DAVID EVANS
AND ASSOCIATES INC.

January 6, 2020

SUBJECT: Response to Ogden Short Plat Resubmittal #2 SUB19-003, CAO19-005, SEP19-009 Lady Bug Trust Request for Information #2 Consolidated Land Use Applications for a subdivision of one lot into two lots, extinguish and create new easements, and steep slope alteration located within the shorelands.

NEW LOT LAYOUT

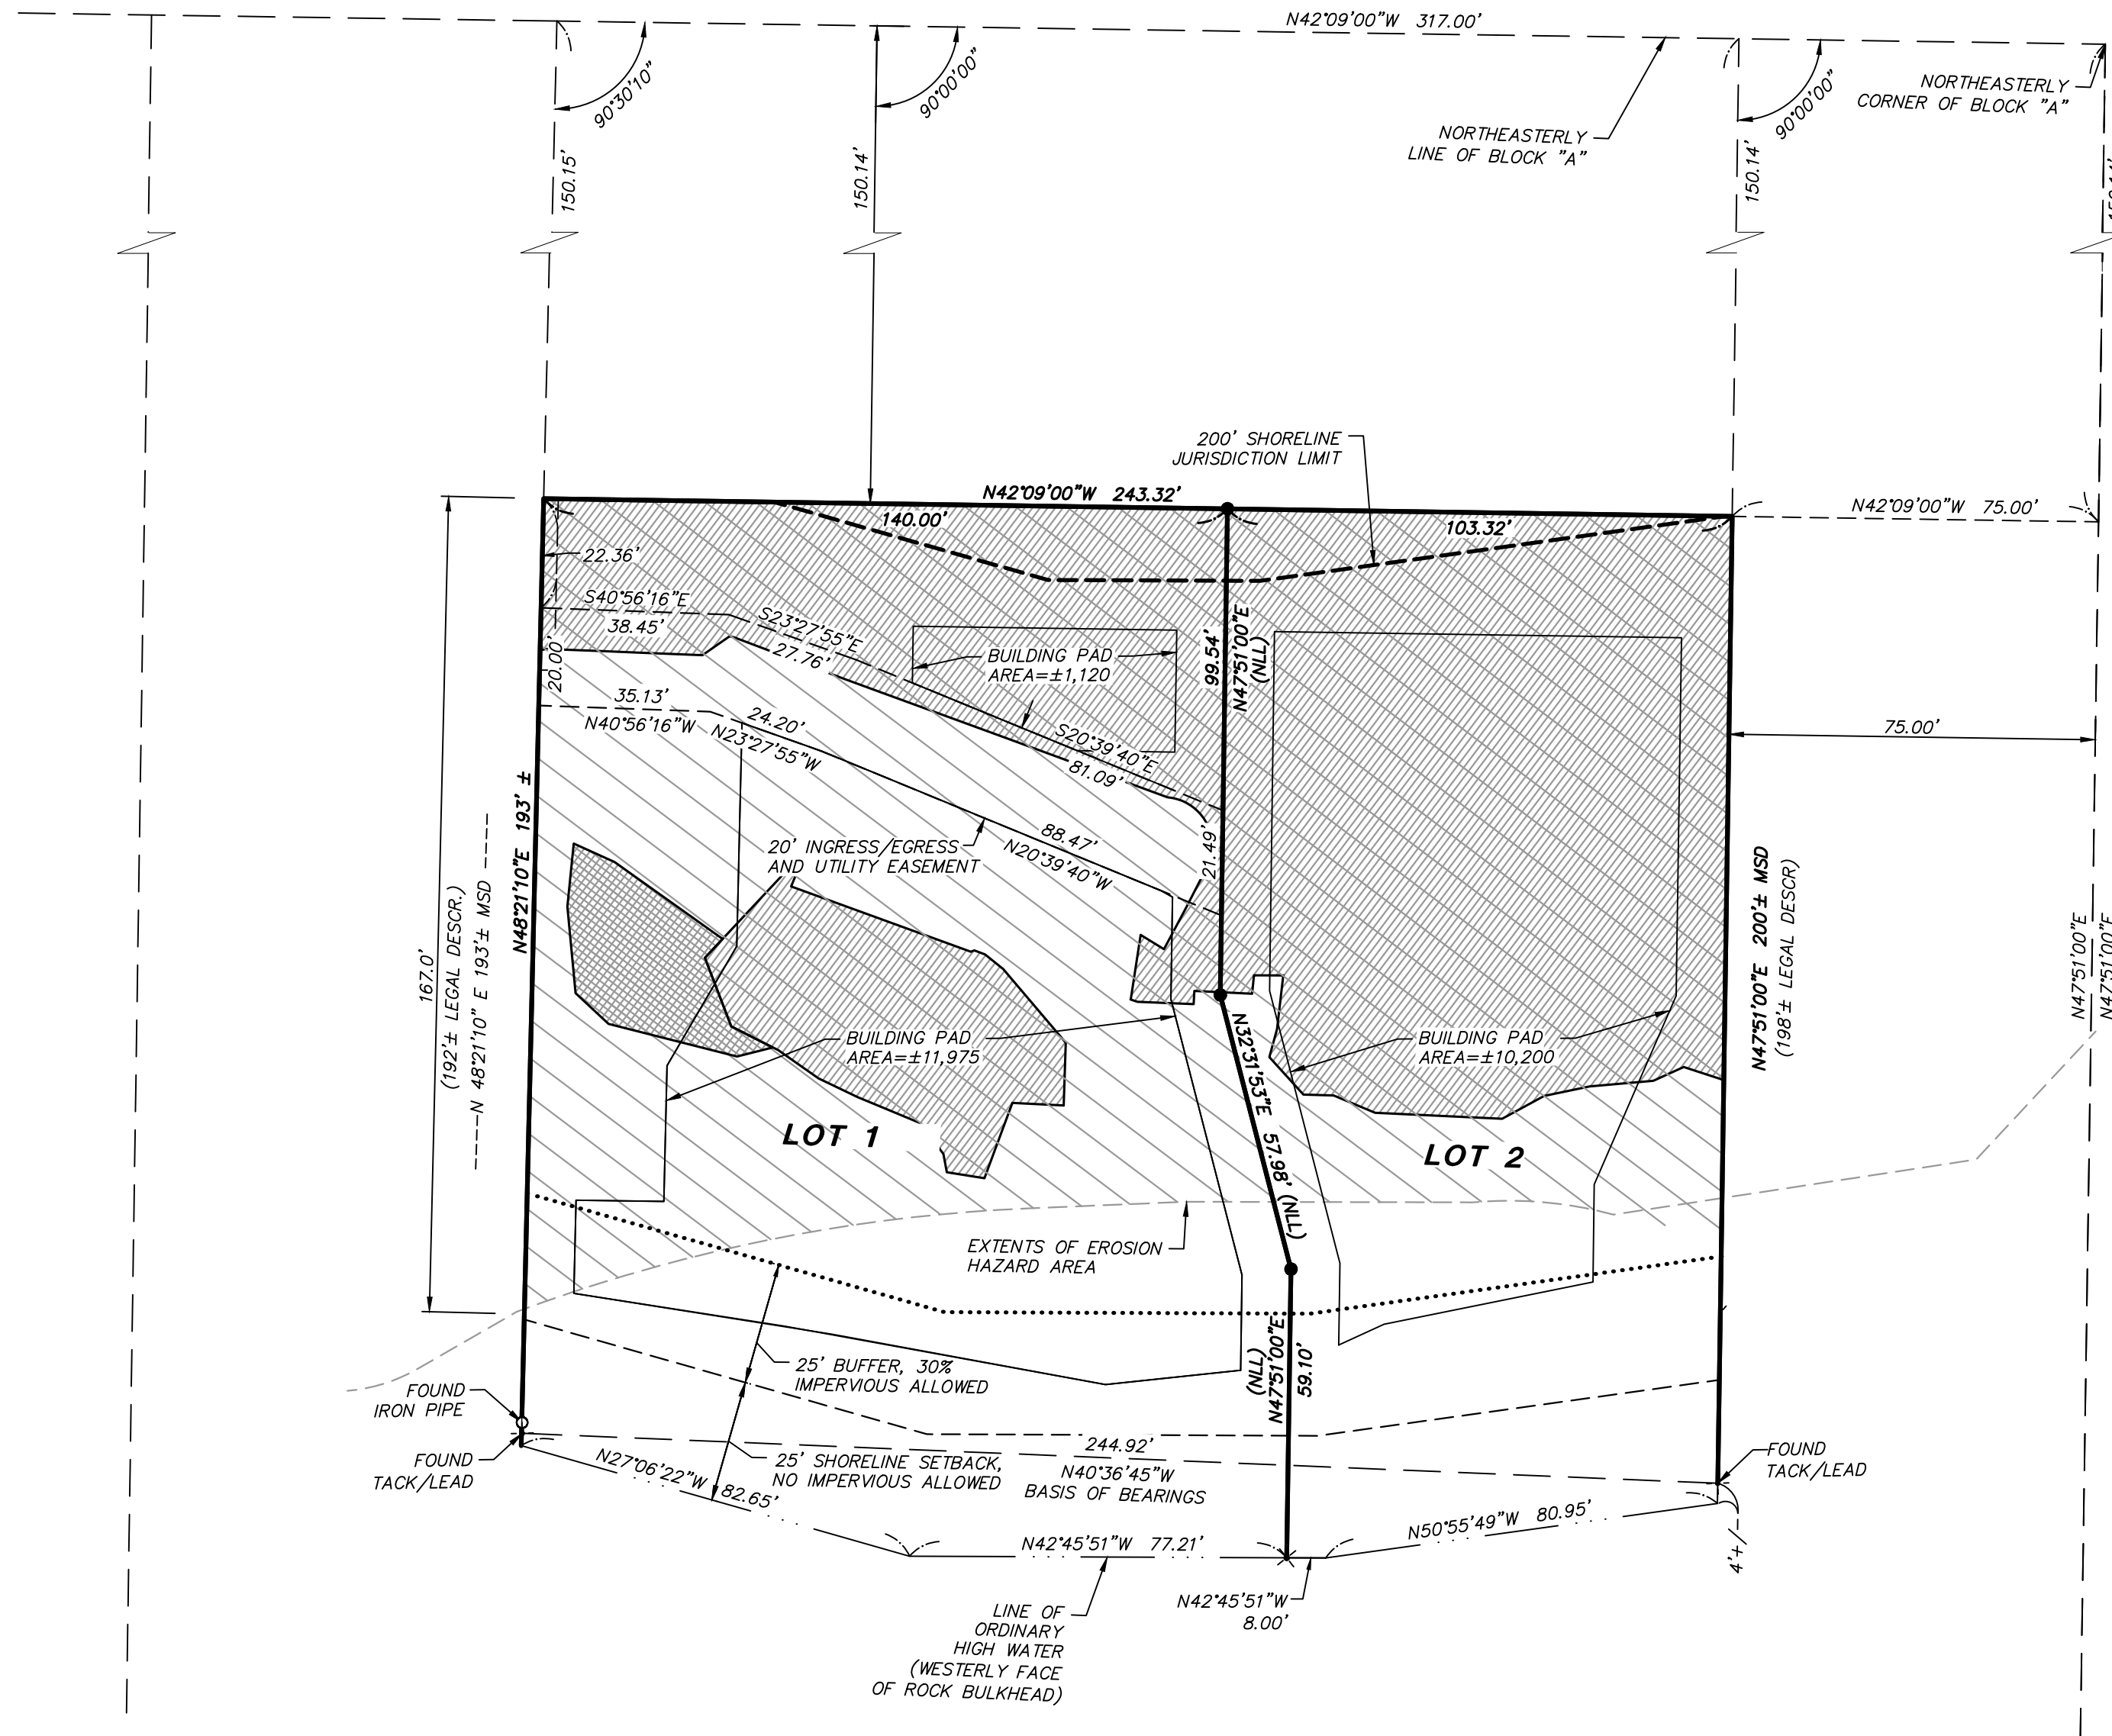
8. The proposed public sewer easement will be 15 feet wide, not 11 feet. Please revise.
Ruji has agreed to accept the 11' foot wide easement via email.
9. Illustrate the proposed sewer easement on all the proposed plan sheets (page 4, 5, and 7 of 9).
The easement has been added to these sheets.
10. Update the plan on sheet 3 of 4 (page 8 of 9) to illustrate the sewer lines and sewer easement correctly.
The sewer lines are shown on these sheets.
